Matthew Fitzsimmons  
El Paso County Planning and Community Development  
2880 International Circle, Suite 110  
Colorado Springs, CO 80910  
RE: PPR2224; 6855 Constitution Avenue Mini Warehouse Building Site Development Plan

This is in response to the comments we received on the SDP from Planning and Engineering. A response to the Engineering comments received with the Rezoning is also included

**C1.1**  
 Sheet 2 of 14

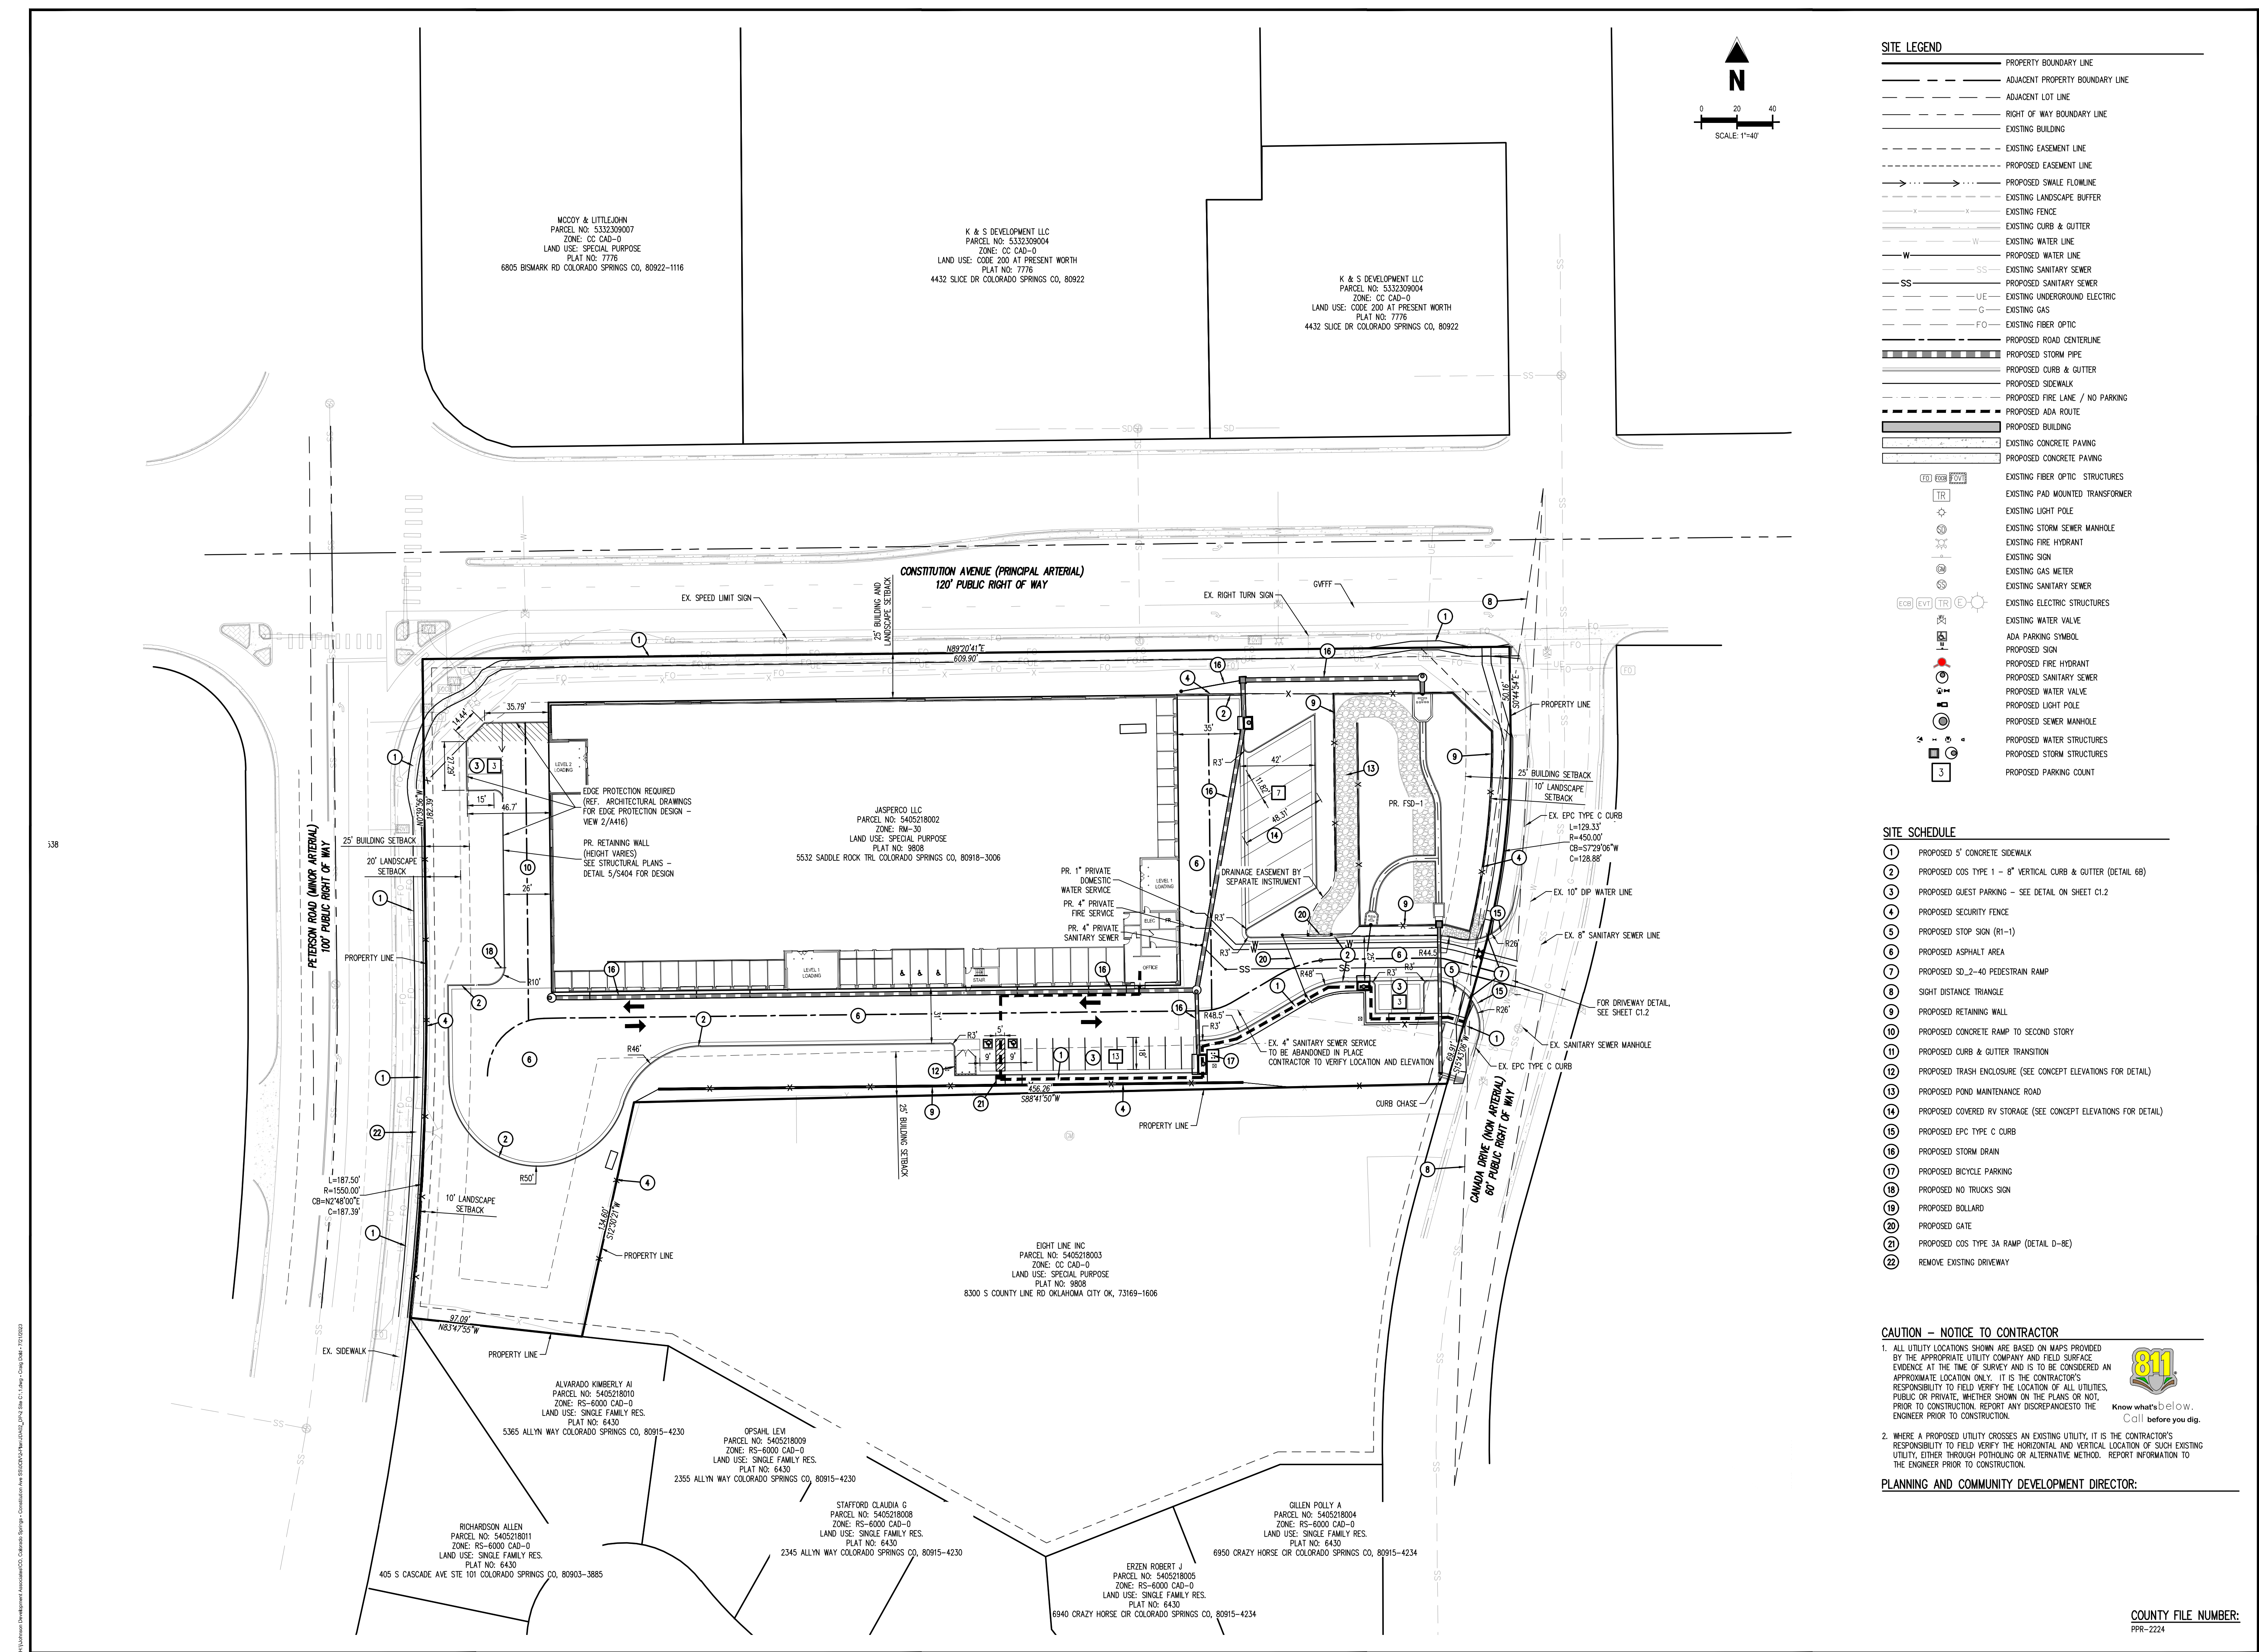
1. Where are trucks expected to turn around, please show the turning radius and the max size truck (with an unskilled driver) that can use the turnaround. **Response: Vehicle tracking for a 30 ft. truck has been added to the plans. There is no interior turnaround for Semi trucks. They are required to pass through the entire site. "No Trucks" sign has been added to the plans for that turnaround.**
2. Loading areas shall be designed so that a maneuvering or parked delivery vehicle will not obstruct any parking or drive aisles used by employees or customers. The south and west elevation has storage unit doors right next to the drive aisles. Please

demonstrate that the lanes are wide enough for two-way traffic and a parked truck. This also seems to be a safety hazard to have a door accessing a drive aisle.

3. Loading bays need to be screened from view from a public road or residential areas. Screening shall meet code requirements. The loading dock on the NW corner is not 100% screened on the landscape page. The landscape screening has now been reduced because the driving area was increased. Please amend. **Response: The turn-around area has been reduced in size to the minimum necessary to turn vehicles around and additional trees and shrubs have been added for screening.**

4. At least one bicycle parking space is required. 5% of the total parking stalls. This bike rack shall be close to the office and well lit for safety. **Response: Bike rack has been added, please see callout 17.**

7. Loading Ramp, do trucks pull into this loading dock? If so, show a detail. **Response: A truck turn analysis on the loading dock has been added to the plans.**

8. Loading ramp turnaround, what are the dimensions? Planning cannot support this change if it reduces the landscaping below the required amount. **Response: Dimensions are added to the plan.**

9. North property boundary, what is the security fence for if there are no doors or windows on this entire side? Please remove on the front if it is not needed and add more landscaping. **Response: The fence has been removed along the north side of the building.**

1. Existing 4" Sanitary Sewer on the south portion of the site. Demo or remain?  
**Response: Existing 4" Sanitary is not shown on survey, we will draw it in and demo it.**

2. Show the existing Fire hydrant and 6" Fireline on the south portion of the site.  
**Response: Survey did not pick up any hydrants on the property, utility locates will need to be done on the site to determine the location of the water line. Currently, a retaining wall is proposed on the south property line that will impact these water utilities.**

3. Install curb stop 2' Inside Property line, see CMD Det. W-38. **Response: Callout added to install curb stop per CSU Det W-38.**
4. Label Existing 10" Water Line. **Response: Existing 10" water line has been labeled.**

5. Label Domestic Water Tap, CSU B1-6 Fire Tap CSU B1-2. **Response: Callout added for domestic water tap per CSU B1-6 and Fire Tap CSU B1-2.**
6. Sanitary Tap per CSU D1-6. **Response: Callout added for sanitary tap per CSU D1-6.**

7. Label existing Sanitary Sewer. **Response: Existing sanitary sewer has been labeled.**

**Response: Vehicle traffic for the site is minimal and concerns for interior traffic impacts are low.**
